# CITY OF ALBUQUERQUE

October 31, 2017

**Re: Broadstone Highlands  
Erosion and Sediment Control Plan  
Engineer's Stamp Date 10-26-17 (K15E034A)**

EROSION AND SEDIMENT CONTROL PLAN

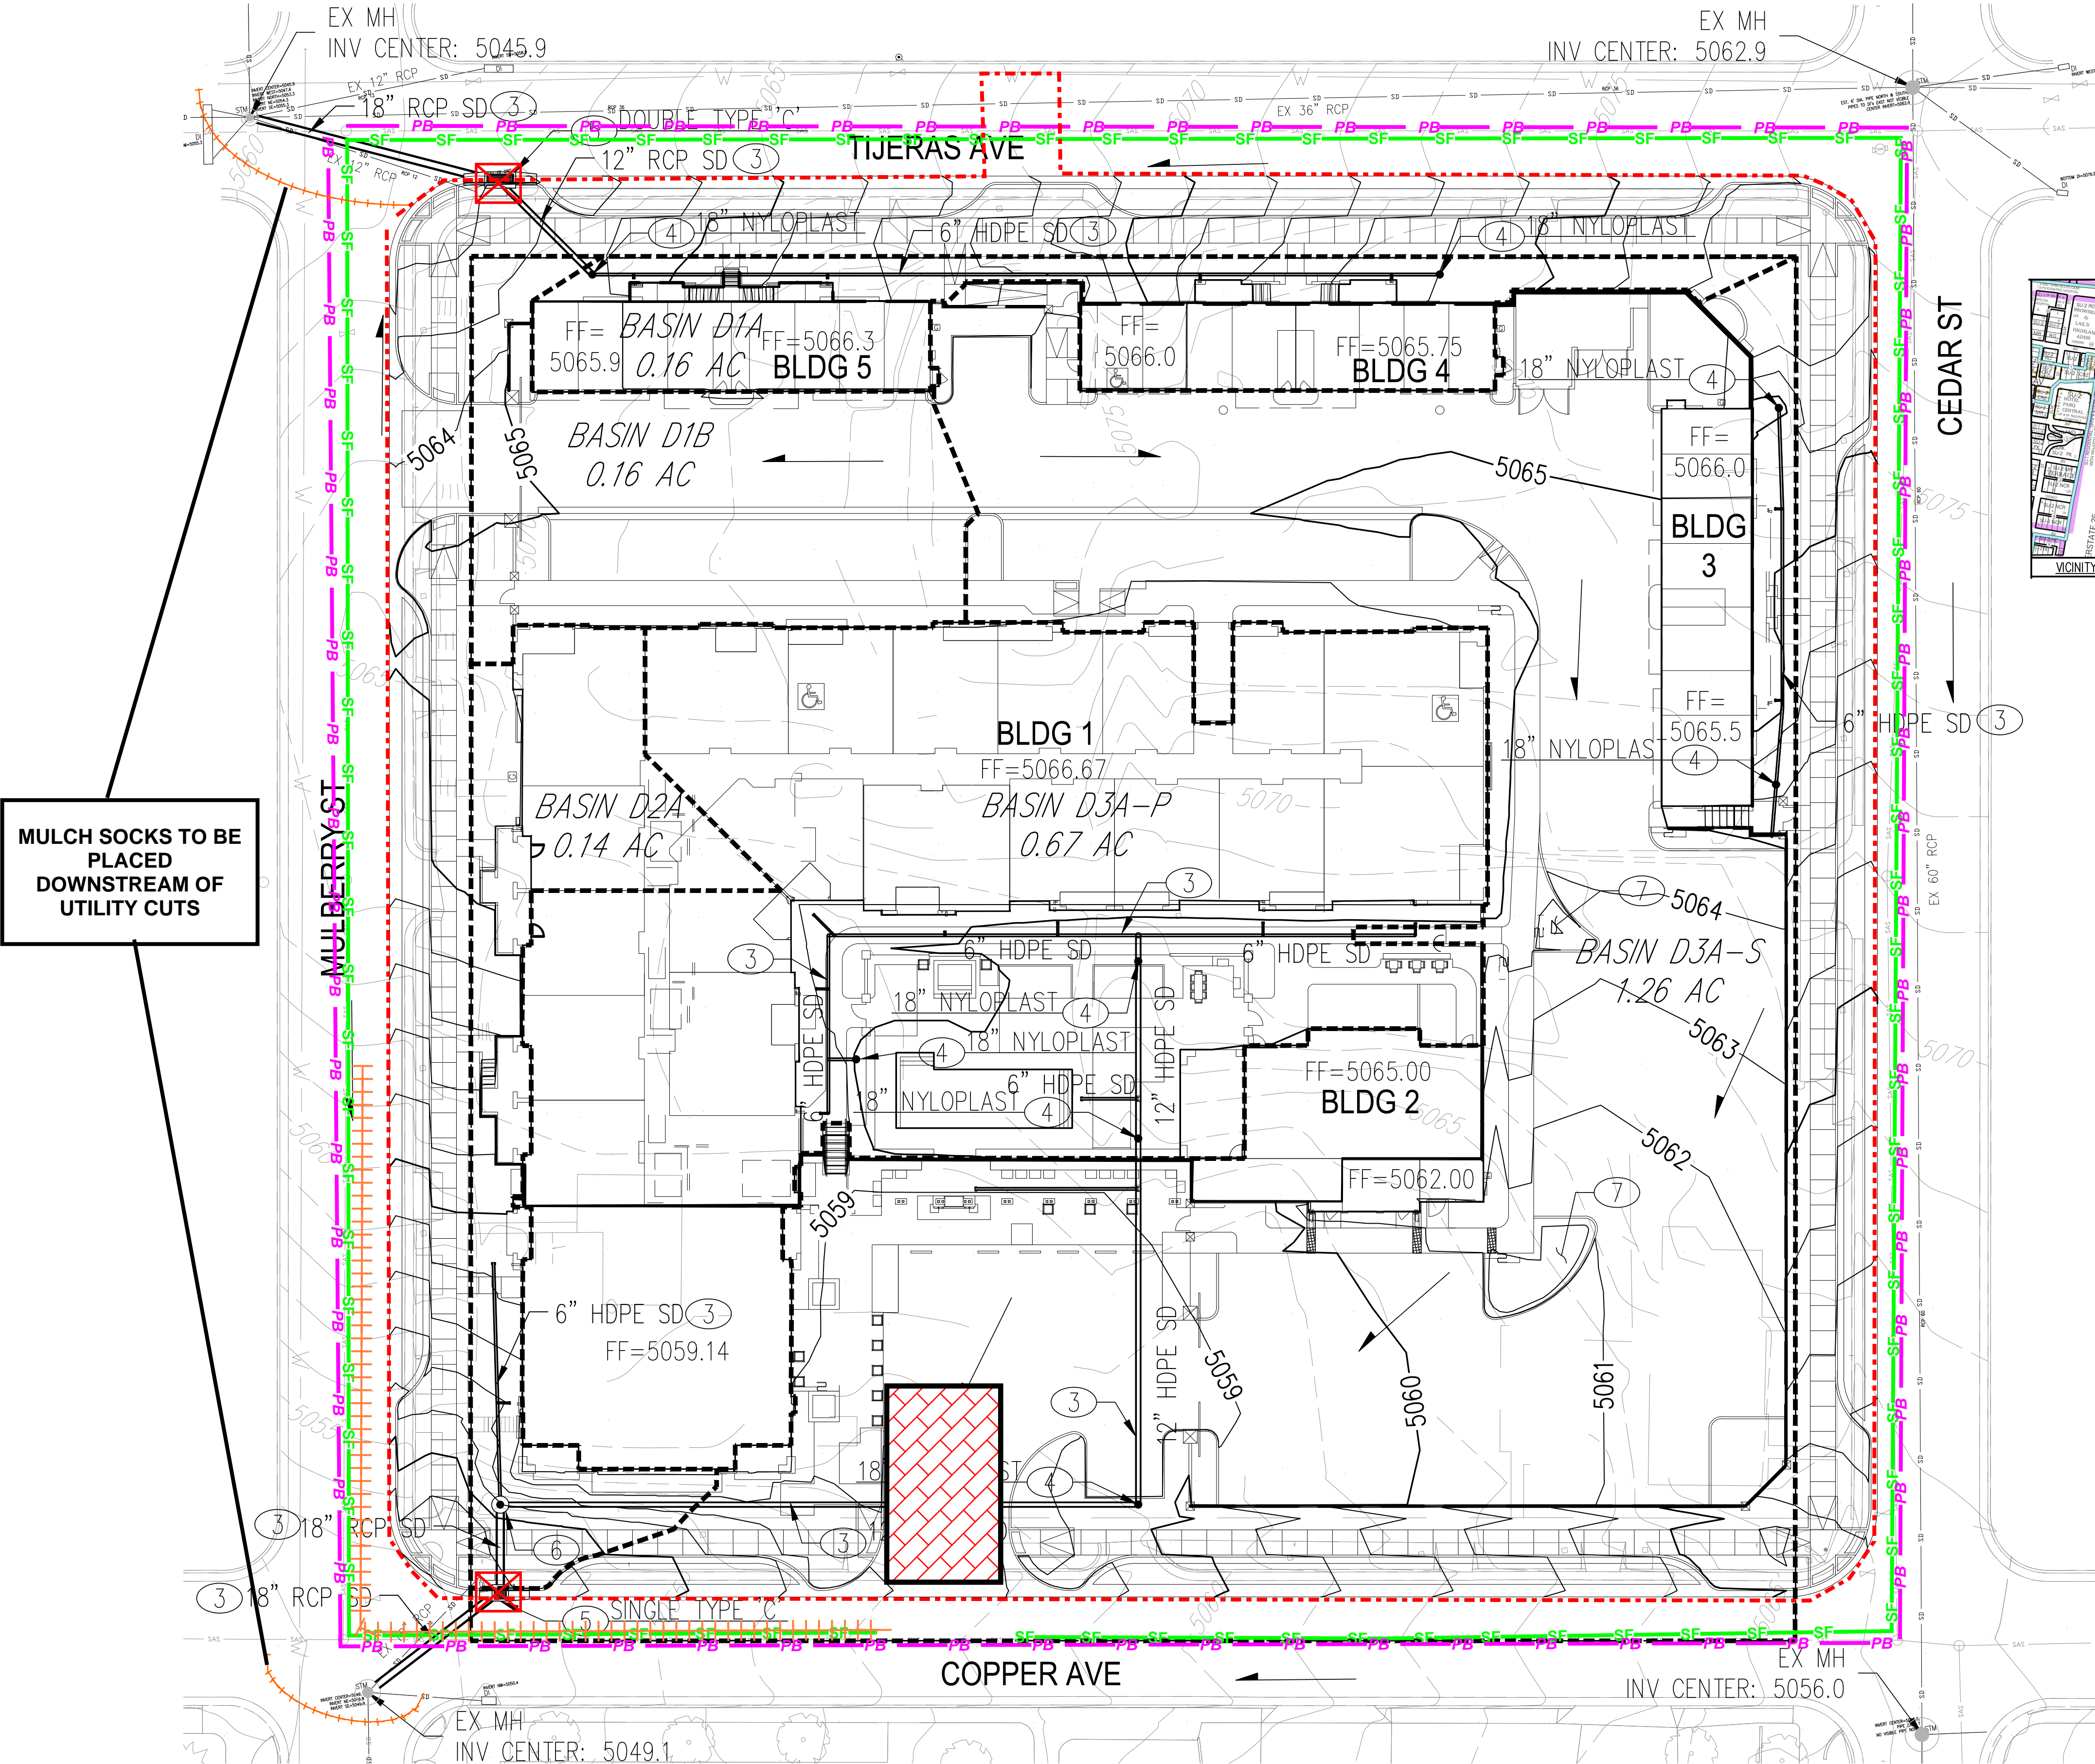
1. Since the streets are steep: for the street work, mulch socks or similar should be placed at the downhill end of each block.
2. On-site slopes are approximately 5%. If the silt fence is loading- up often or gets blown-out in the southeast corner, a pond will be required.
